## Turner Family response to EXA Question CA 2.48

*“Please explain further how the boundaries could be realigned more efficiently to reduce the area of the proposed acquisition”*

PLAN 1.B

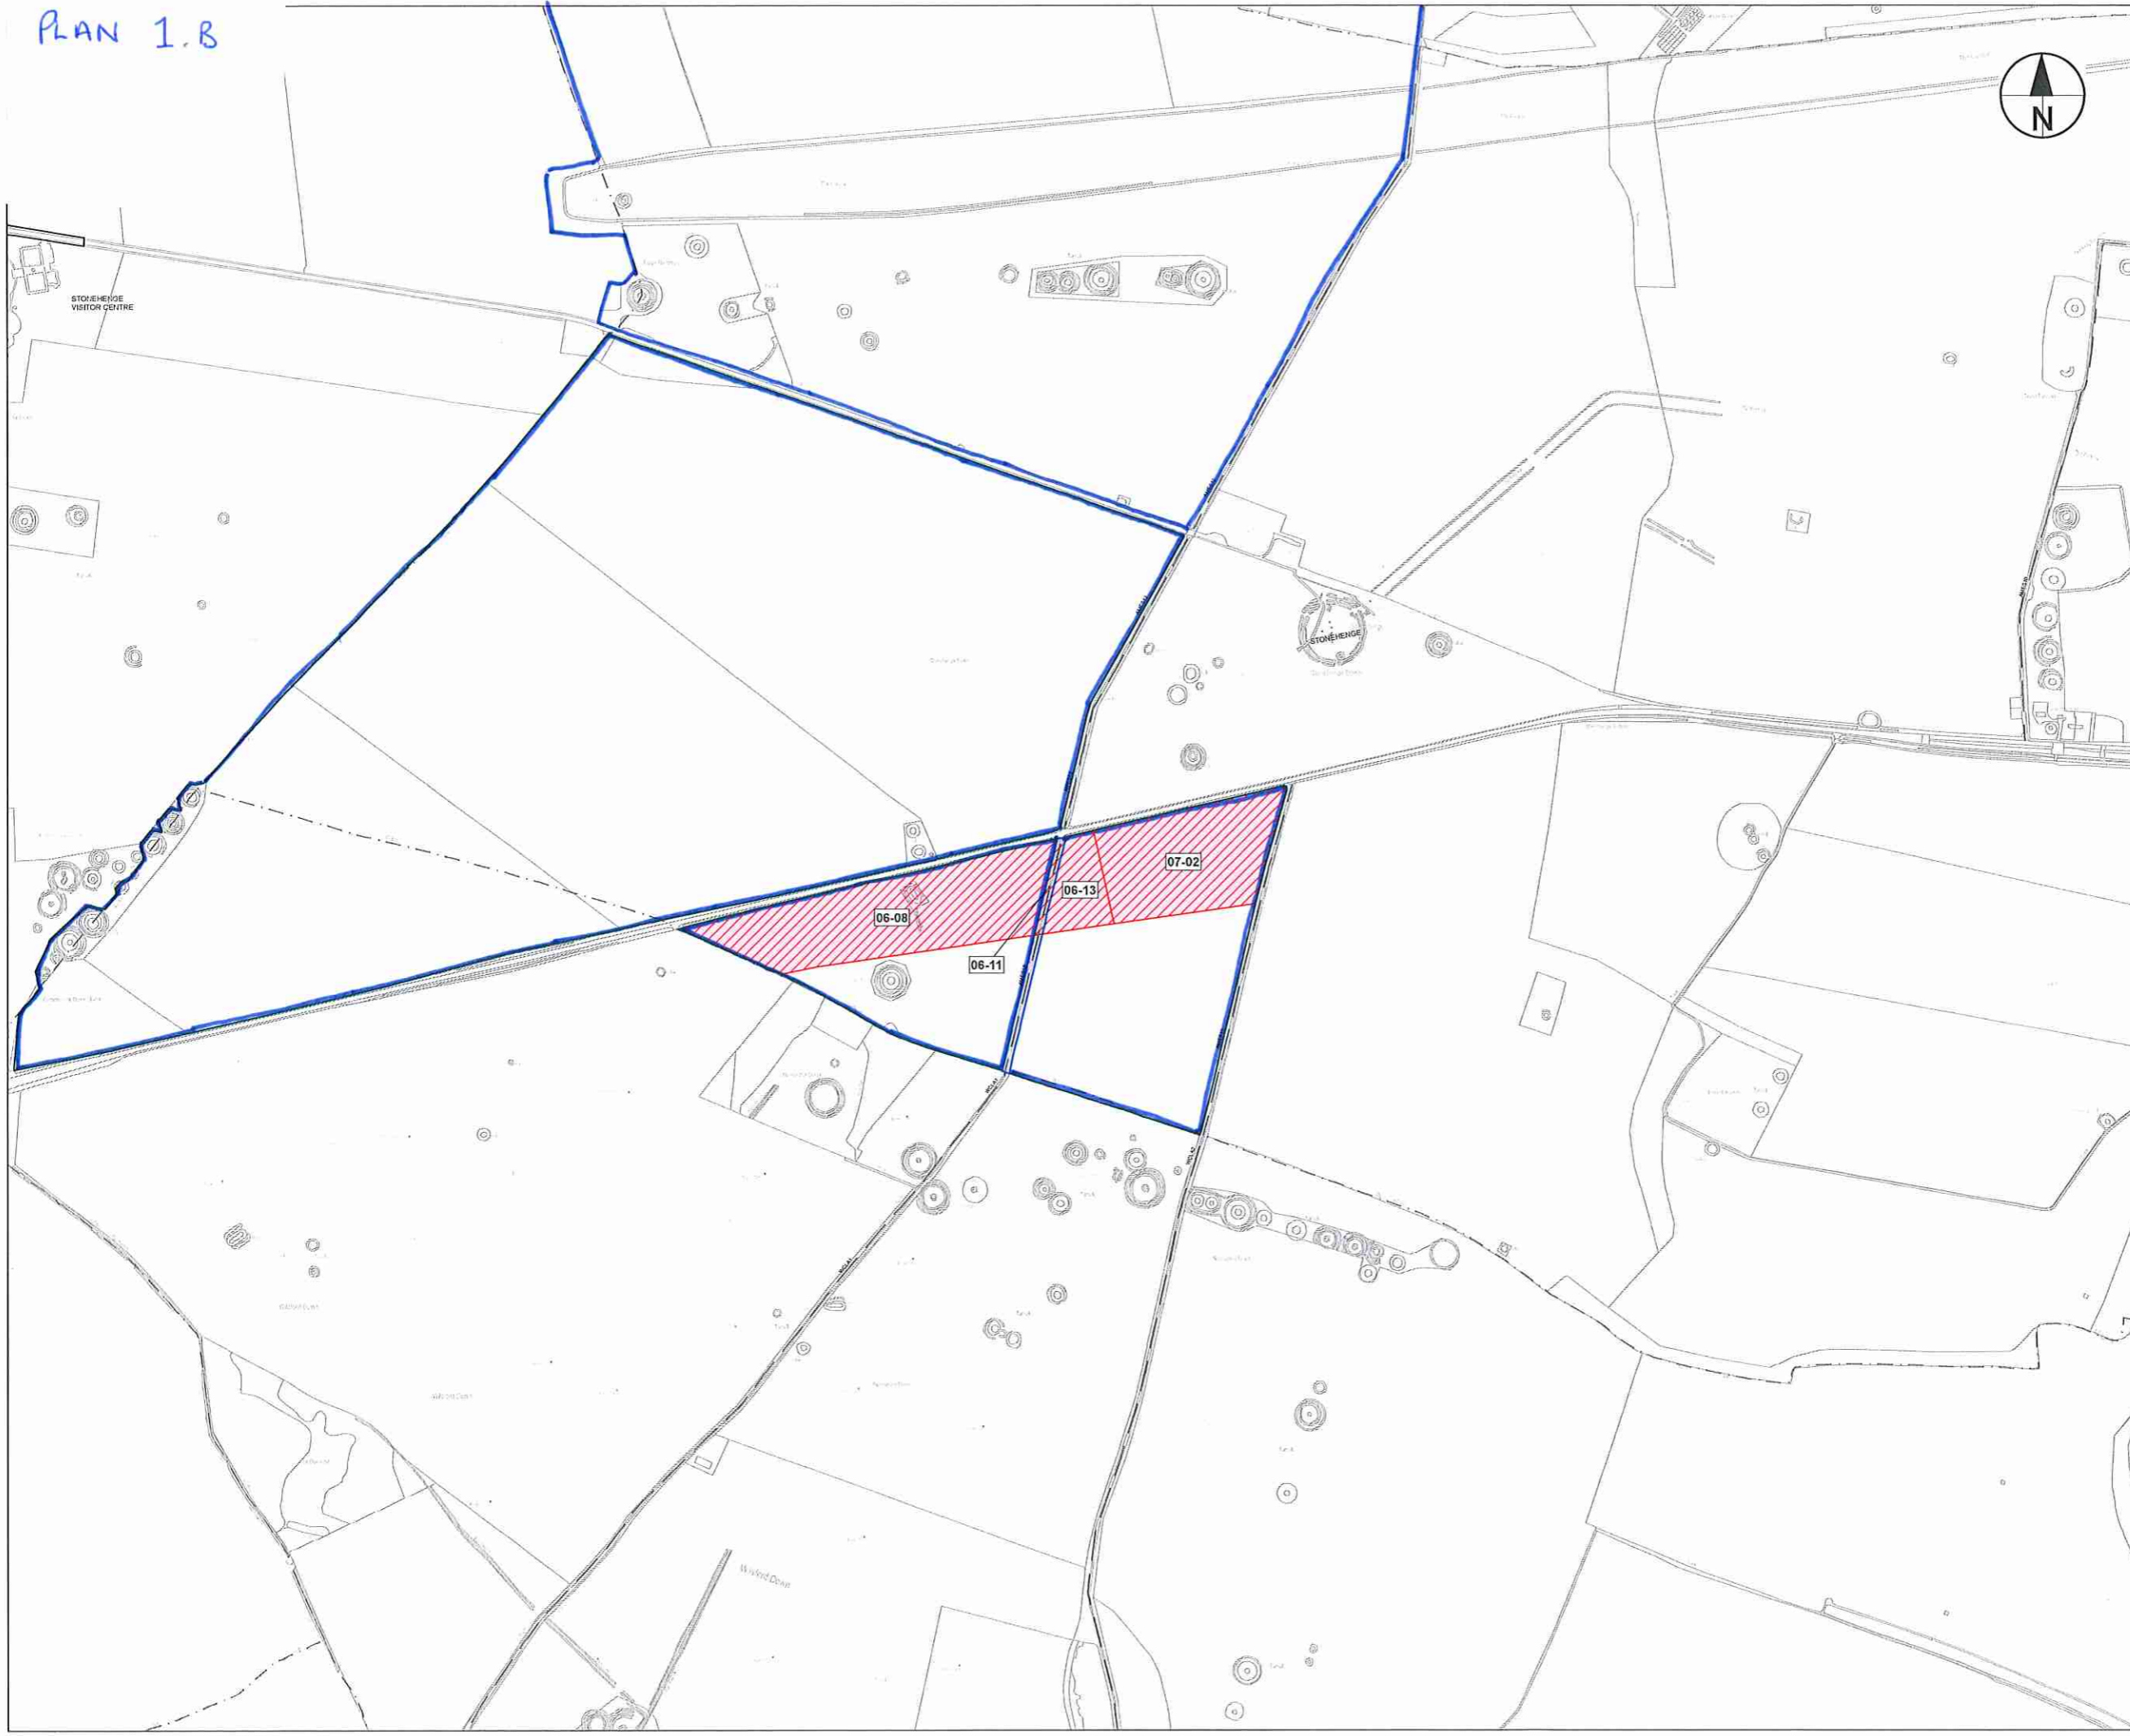
- SP 1 to the east of the B3083 has been deleted from the scheme but the red line remains in the original position. As a result, the area of land take on the south side of the new road is excessive and prevents the use of invaluable grazing land near the main farm buildings. The red line also prevents the Turner family from making a minor planning change to the curtilage of Foredown House as part of proposed building alterations to screen the new road. The red line should be moved north to match the area required for landscape reprofiling.

- SP2 should be relocated west towards the B3083 and redesigned to be narrower in shape to reduce the area of land take. This would eliminate an unworkable pocket of agricultural land on the west side of the pond.

- SP3 should be moved north to be as close to the carriageway as possible. The proposed location of the maintenance access track from the south results in unnecessary land take and creates an unworkable field area to the west side of the pond. Changing the route of the track so it runs east/west parallel with the new road carriageway with access gained from Green Bridge 2 whilst being slightly longer, would avoid another access point onto the old A303 and eliminate the unworkable field area to the west of the pond.

- SP5 increases land take and sterilises productive farmland unnecessarily. A better location is further east, closer to the roundabout, thereby minimising land take and the unnecessary spread of road infrastructure. It is admitted by HE that a conservative ground infiltration rate has been used, resulting in oversized ponds being specified in the design. It is requested that more representative ground infiltration data is used to minimise the land take of all the settlement ponds.

- There is excessive land take to the north-east side of the new dumbbell roundabout. The CPO boundary should align with the highway boundary on the south side of the realigned A360.
- The land take on the west side of the A360 to the north of Kighton Farm Track heading north to the Stonehenge Visitor Centre roundabout is excessive and should align with the new highway boundary.
- The proposed compound areas to the north side of the new A303 and realigned A360 are excessive and should be reduced in size.

- The proposed compound to the east side of the B3083 should be relocated to the west side of the B3083 onto land that is subject to landscape reprofiling.

- The area of land take significantly exceeds the proposed landscape reprofiling area and should be reduced in size to match this area.
